The following comments apply to the **VA 23 00003** Zoning Variance Application Submitted by:
Land Owner Sparks Park LLC C/O Lisa Weis
Agent AJ Sandhu
Tax Parcel number: 778834

Easton Travel Center SEPA SE 23 00010

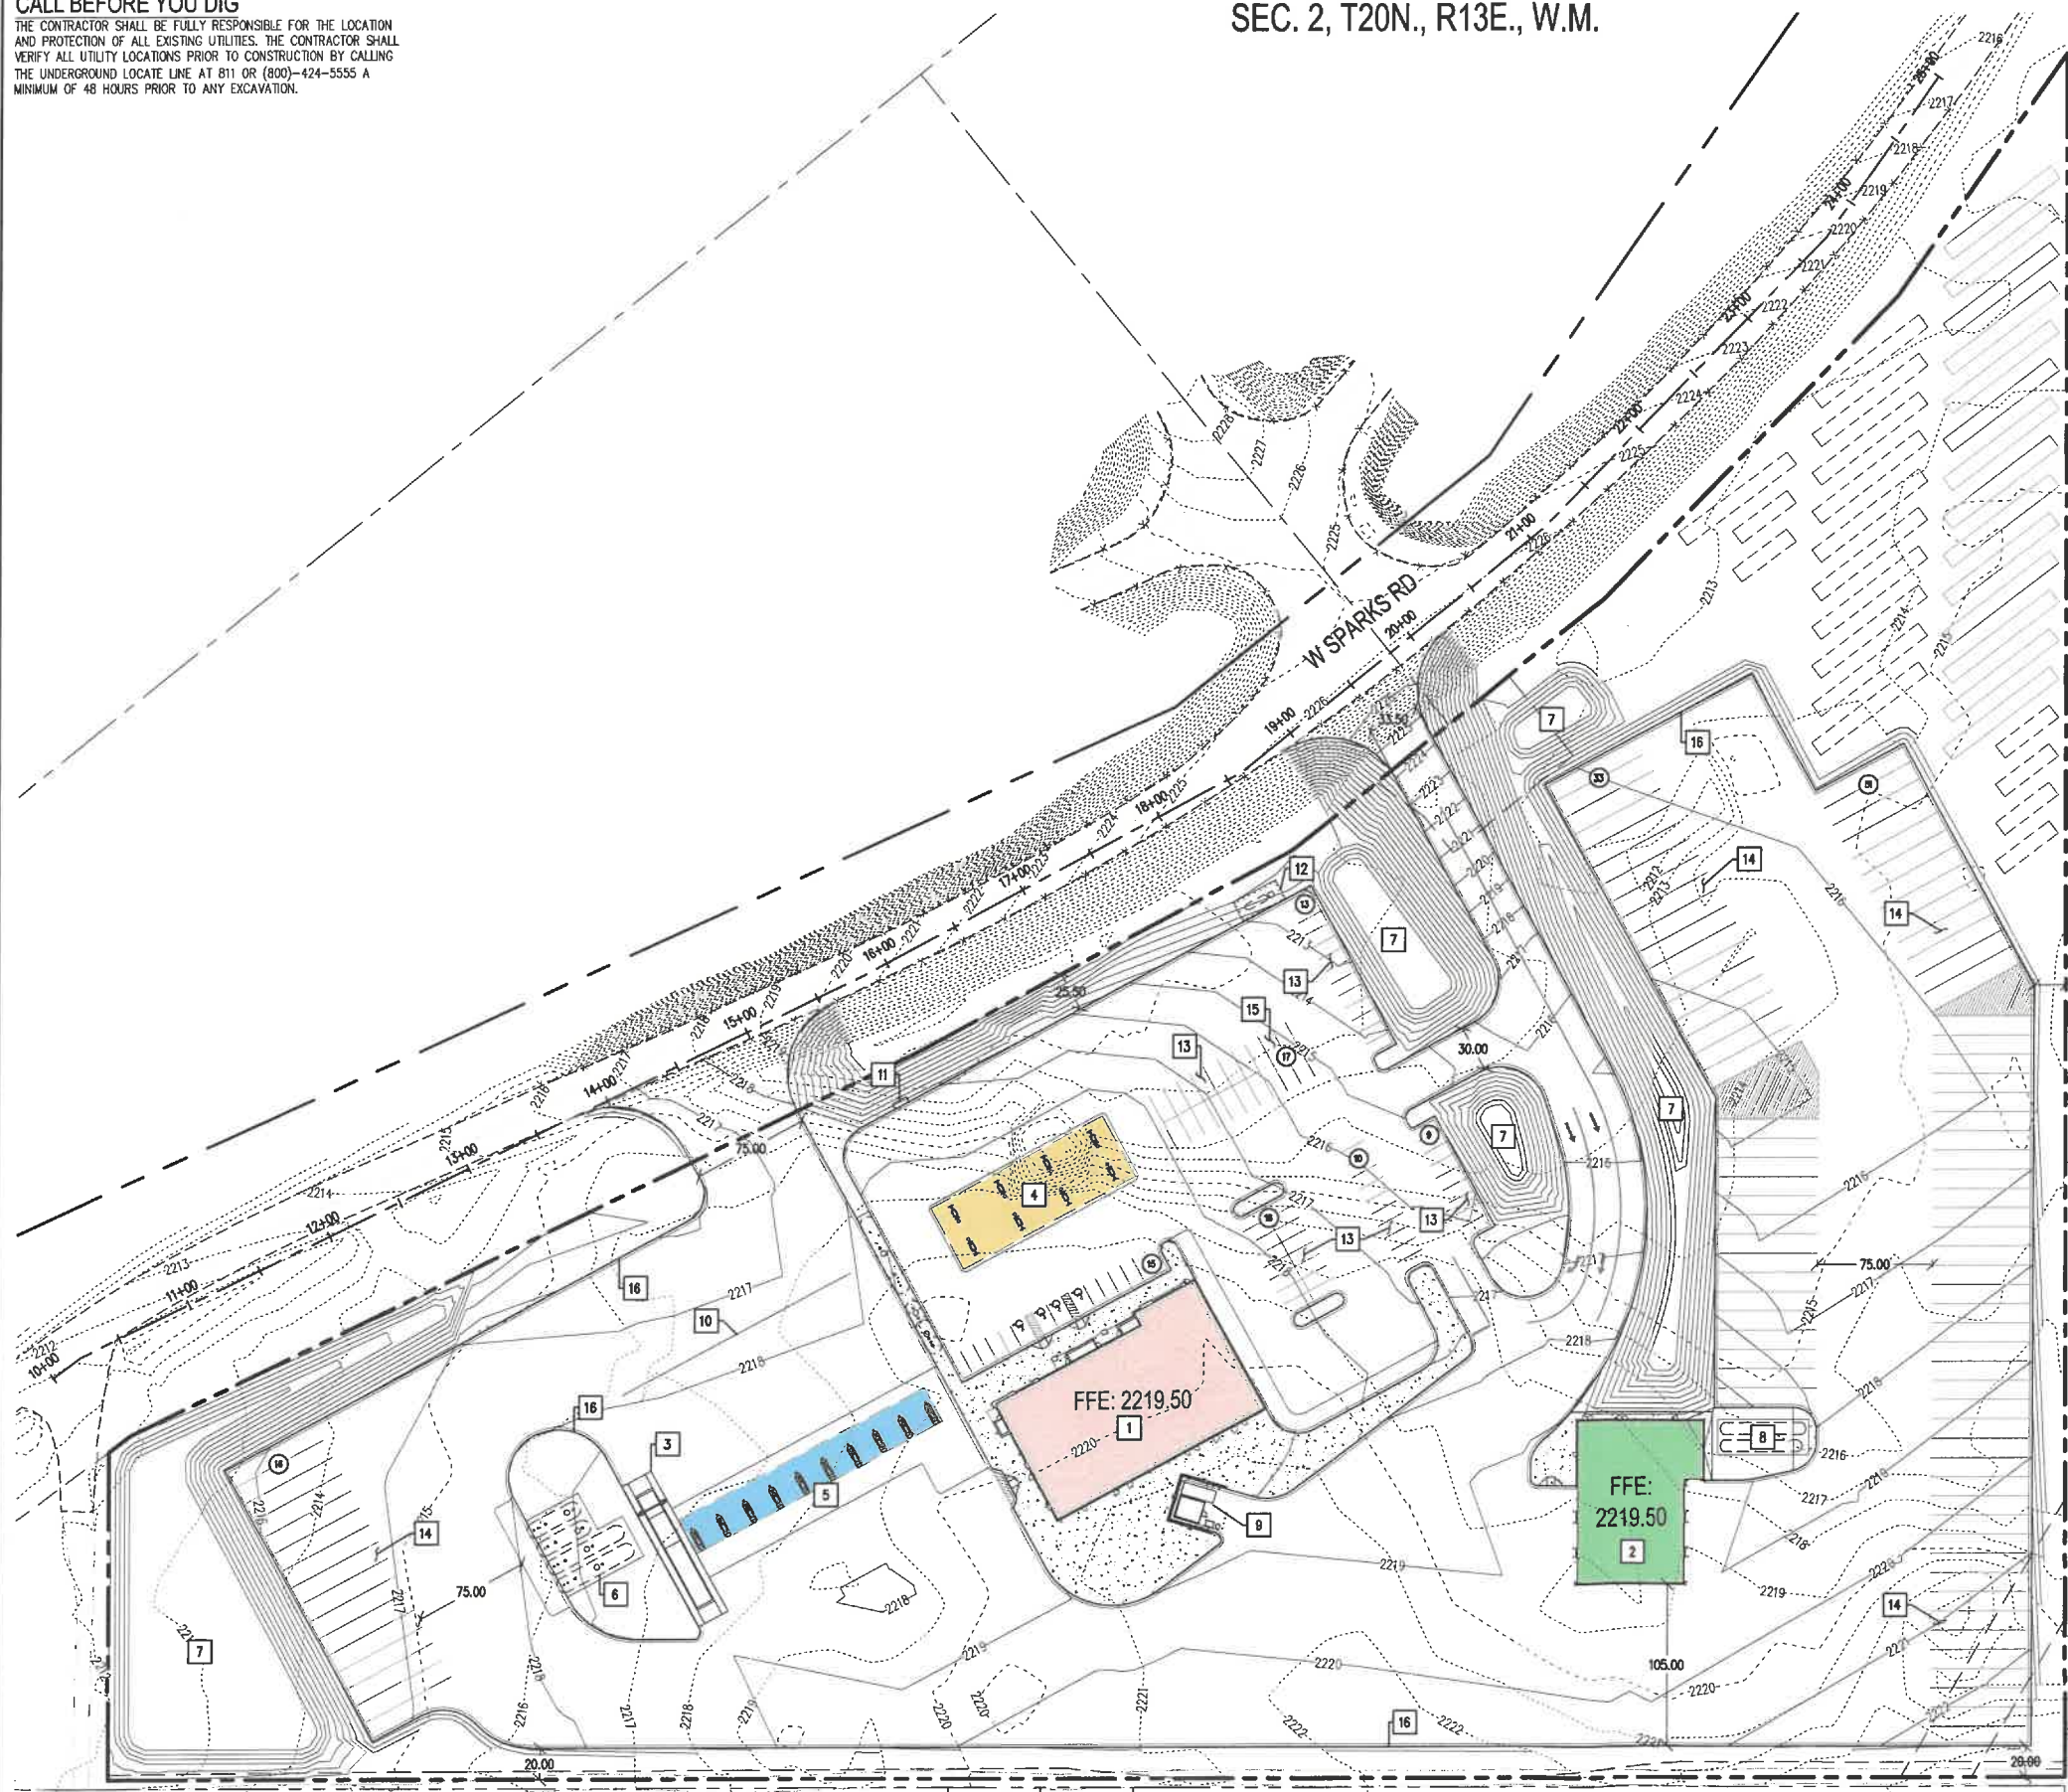
The attached Preliminary Site Plan does not clearly identify Septic tank, drain field and replacement area. The document is almost impossible to read due to the poor quality. It is difficult to tell if the additional items required by the Site Plan submittal are included in the submitted document. Without clarity it is difficult if not impossible to make constructive comments on the site plan for this document.

The applicant also indicates that along with the difficult access there is highly restricted visibility due to the lower site topography. The topography should be of concern regarding run off especially volumes from snow melt. Also of concern is the fact that the designated truck parking is al the lower portion of the parcel which will likely cause a considerable challenge to trucks using that area during snow events causing a possible traffic flow problem at ingress and egress points.
